Section 96A of the Town & Country Planning Act 1990 (as amended)
Town and Country Planning (Development Management Procedure) (England) Order 2015 (as amended) - Article 10

Application for a Non-Material Amendment following the grant of BR/54/16/PL for reduced height of parapet to CDIO, bridge link to stage 1 roof replaced with fixed verticle ladder, site layout updated to remove eastern road link and minor adjustments to car park layout (no. of spaces unchanged).

University of Chichester, Upper Bognor Road, Bognor Regis,

DRAWING TITLE
East Elevation

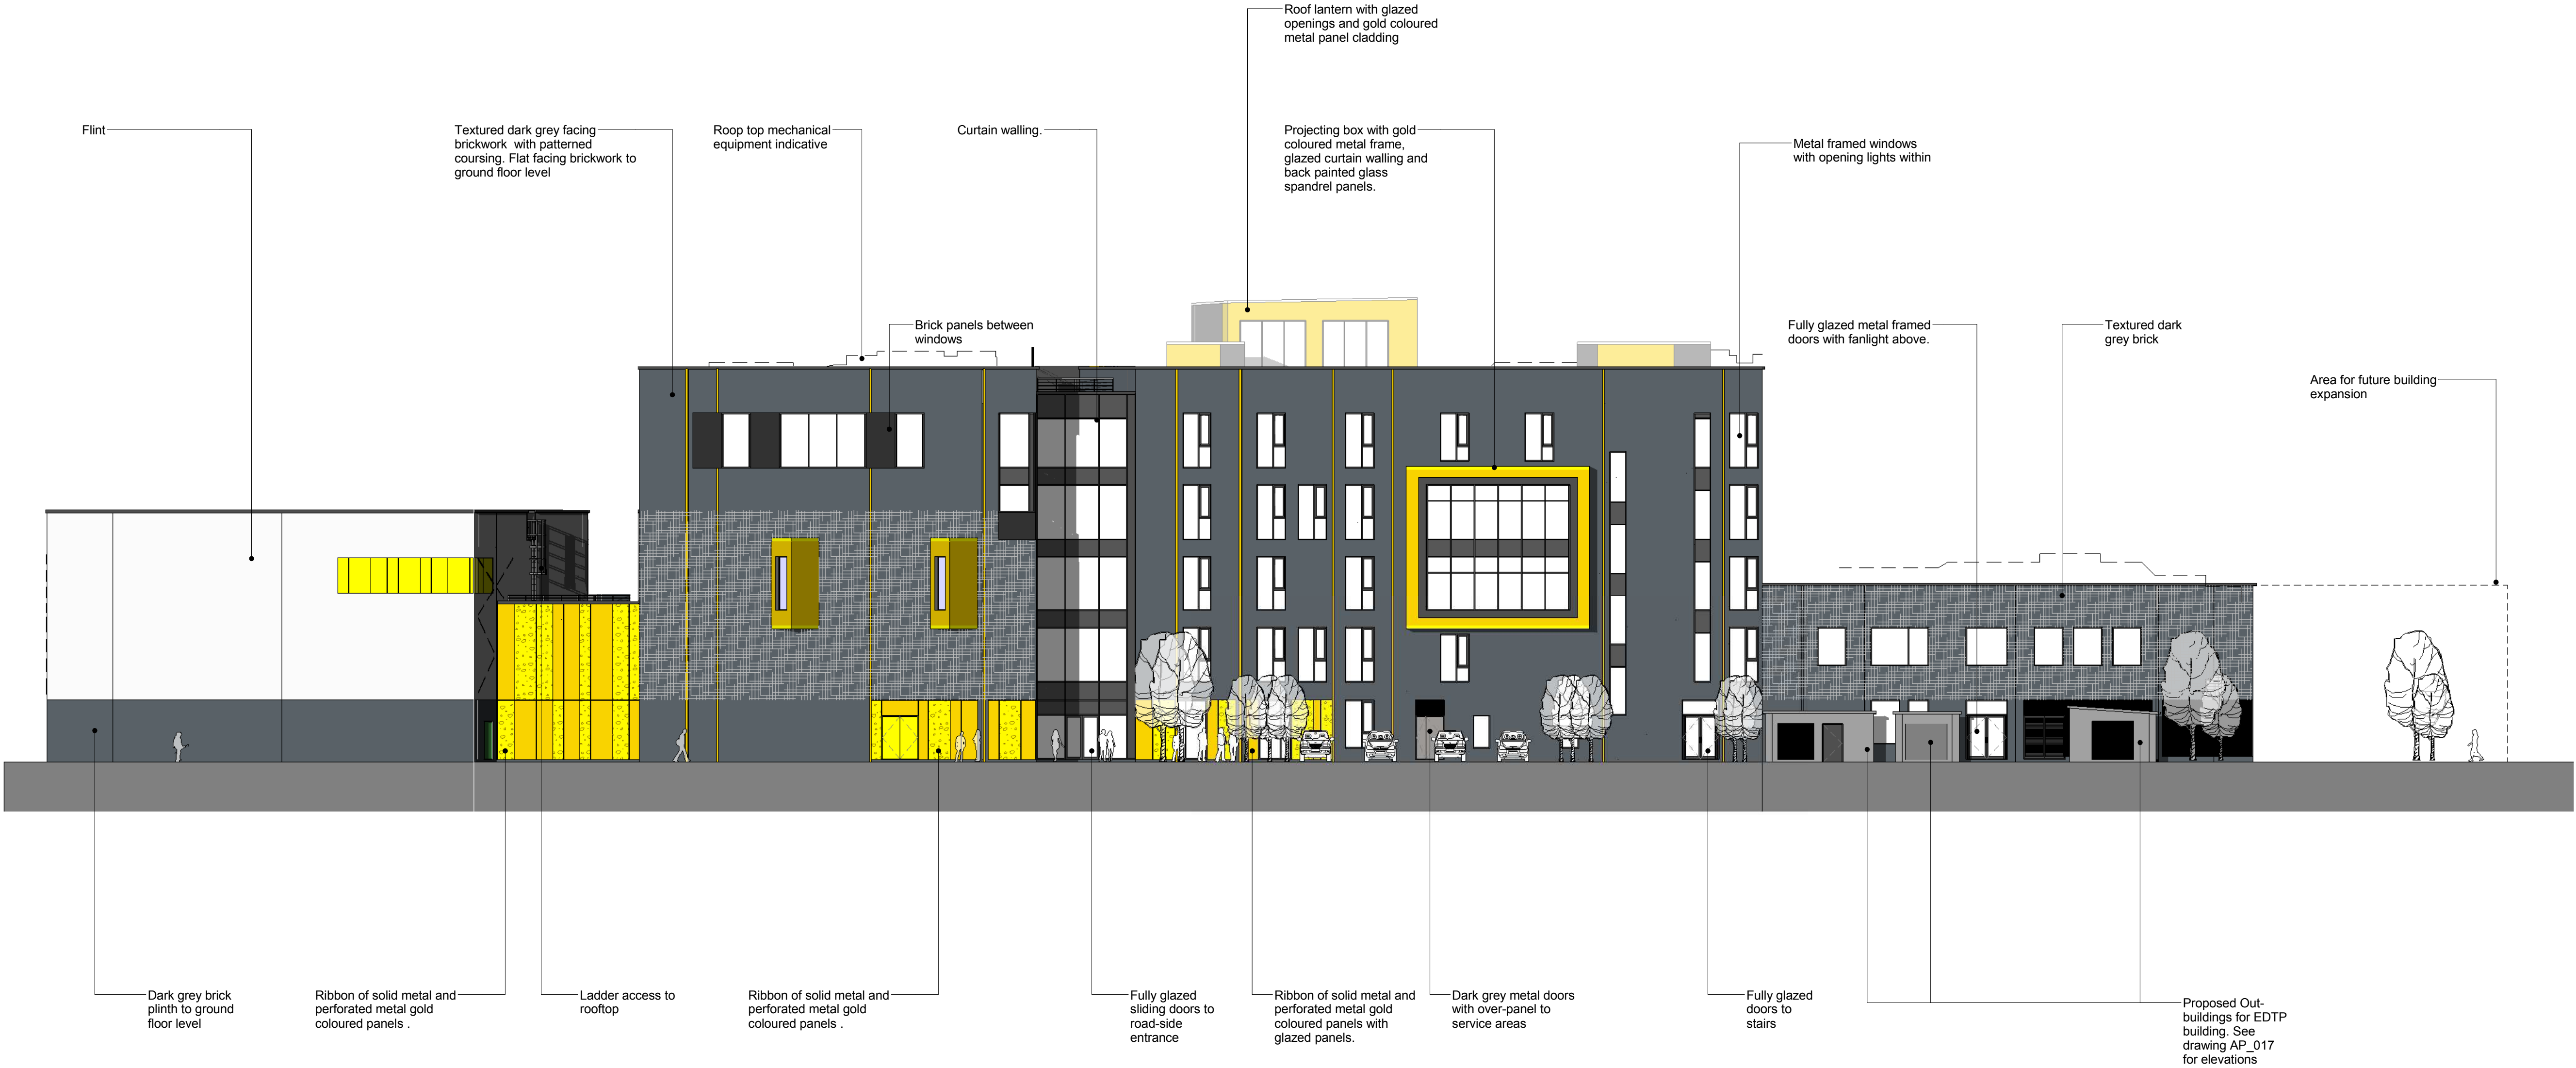
It is noted that the proposed block plans appear to show alterations to the landscaping/external layout to the west of the proposed new building and adjacent to the Crinkle Crankle wall including the removal of a proposed pathway shown previously. In addition, the elevation and perspective drawings show changes to the proposed colour scheme for the buildings. These changes have not been assessed as they are not included within the application description and therefore, no approval is given for either of these amendments.

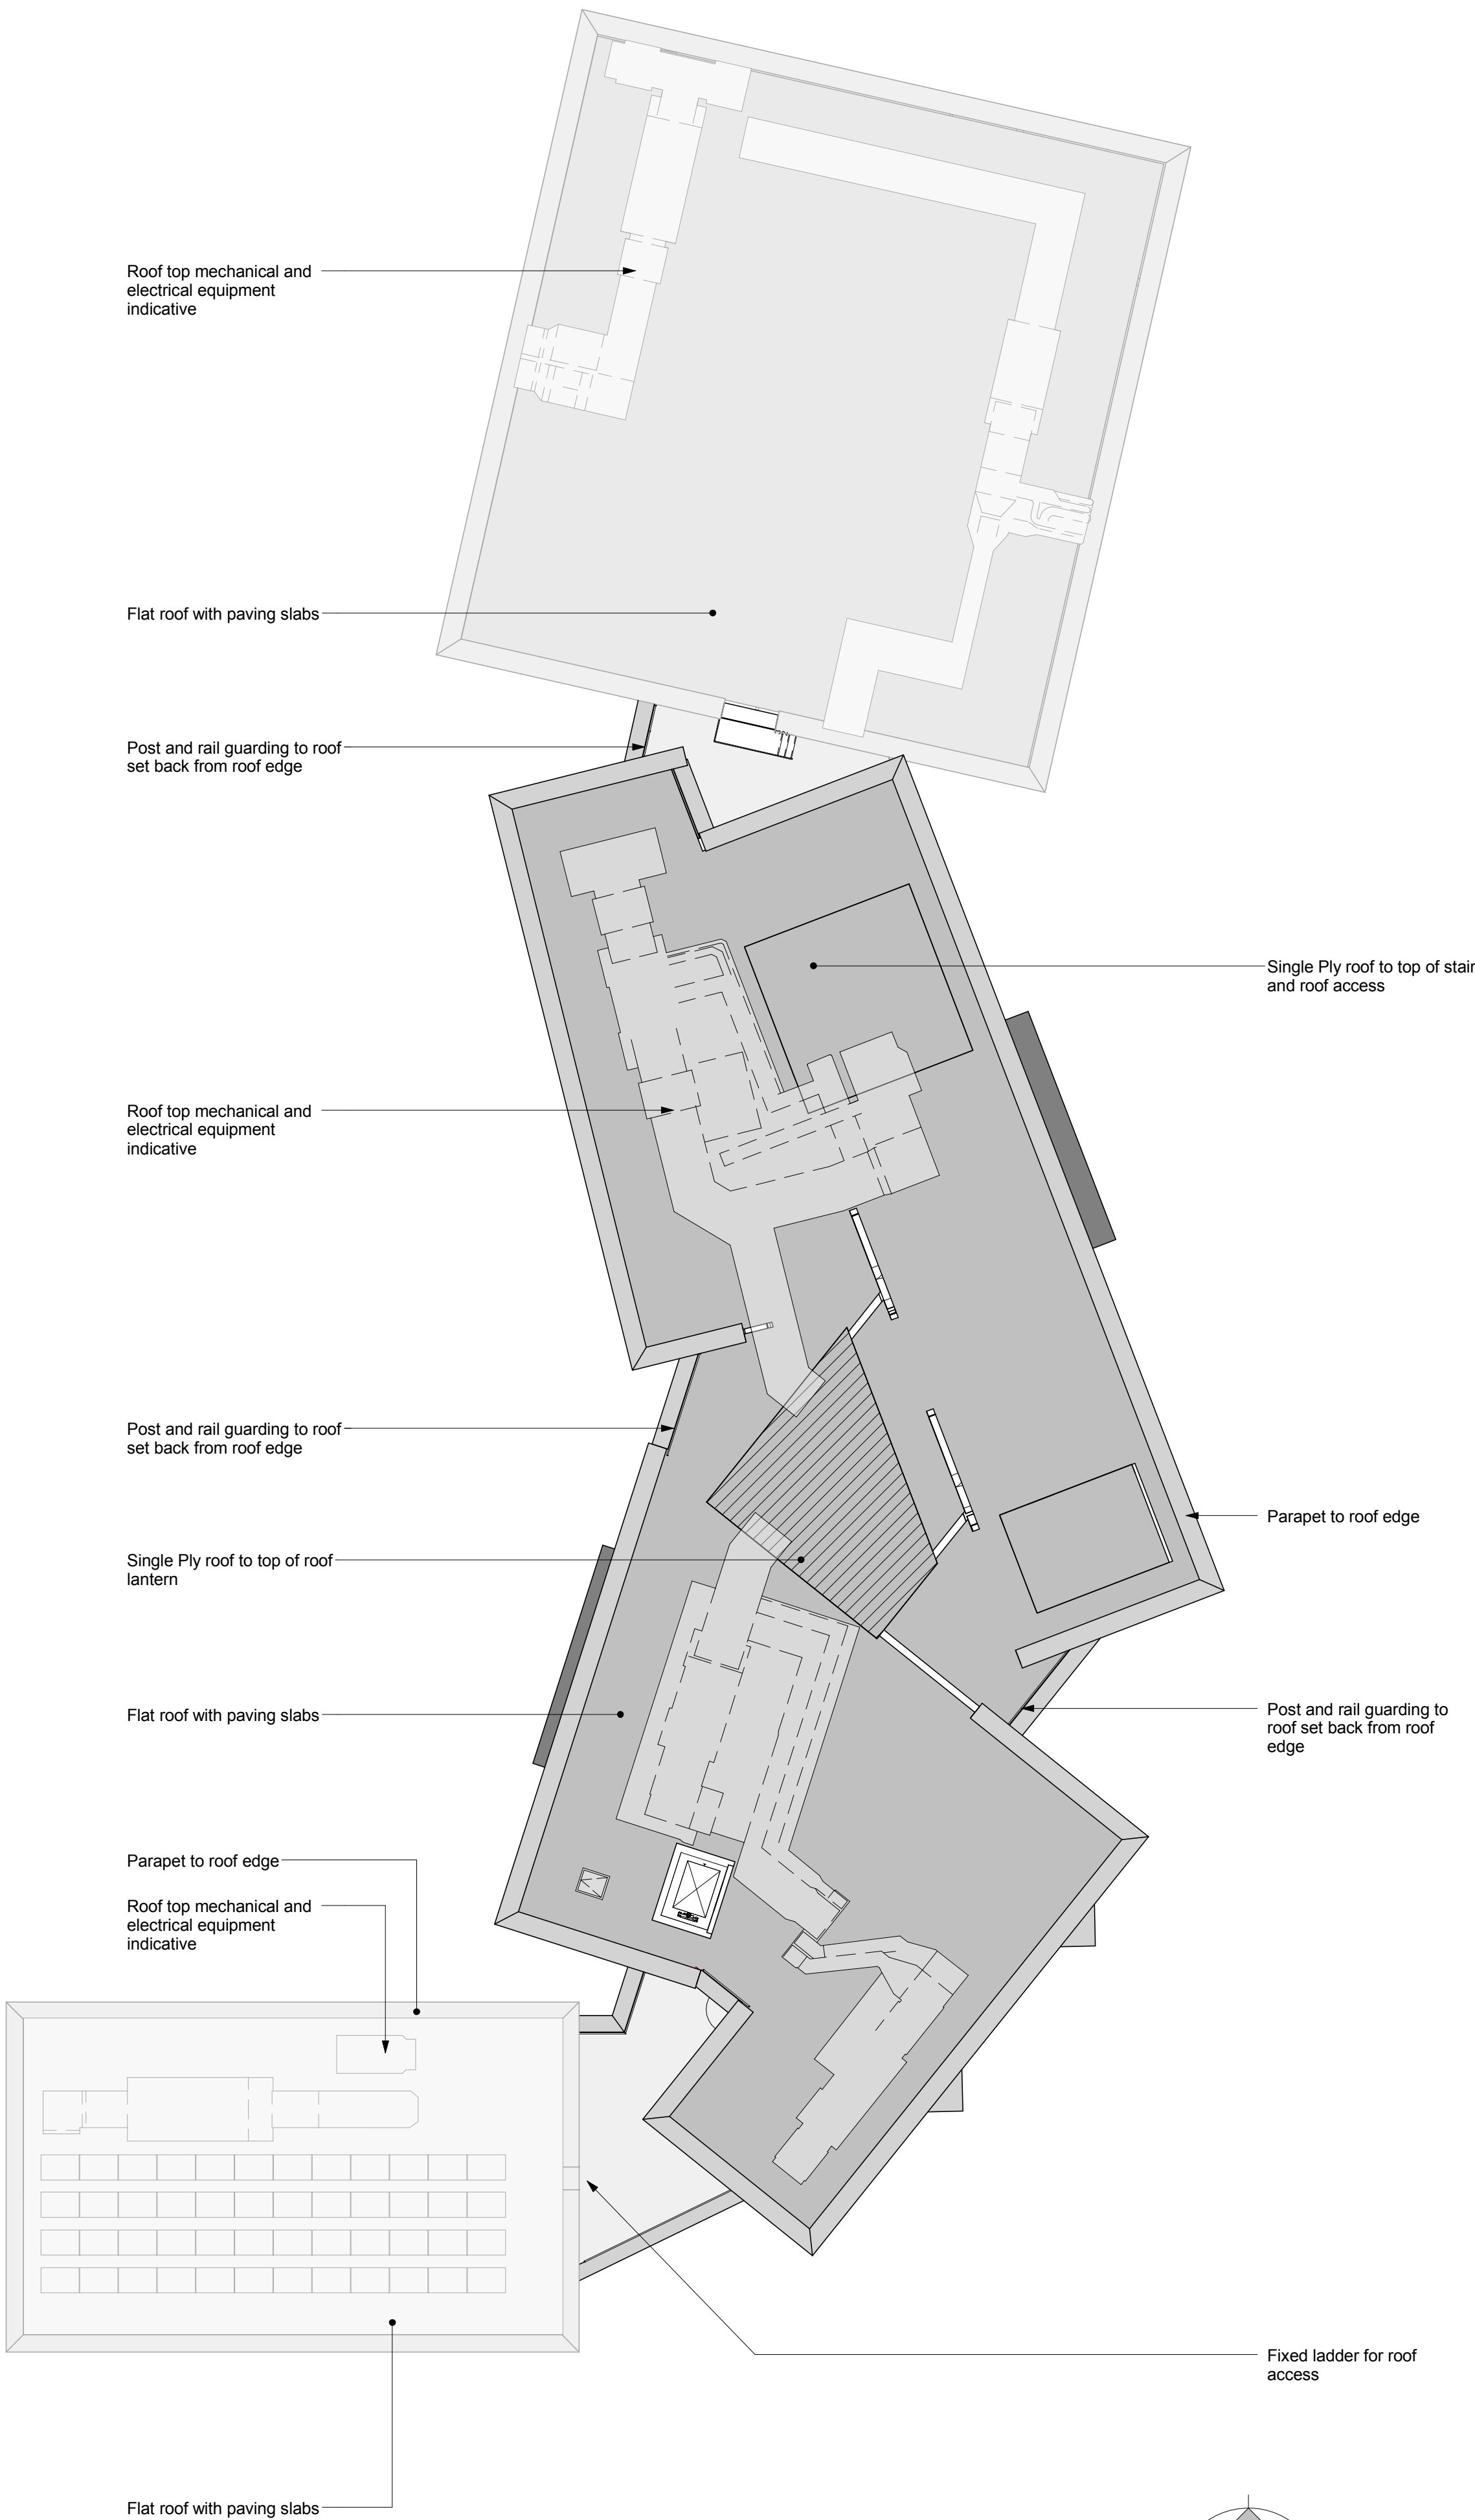
1. Reduced height of parapet to CDIO Building;
2. Bridge link to stage 1 roof replaced with fixed vertical ladder;
3. Site layout updated to remove eastern road link; and
4. Minor adjustments to car park layout (no. of spaces unchanged).

I have compared the submitted drawings with the approved and agree that these changes can be treated as non-material minor amendments to the approved scheme. Therefore, the plans listed below now become part of the approved plans.
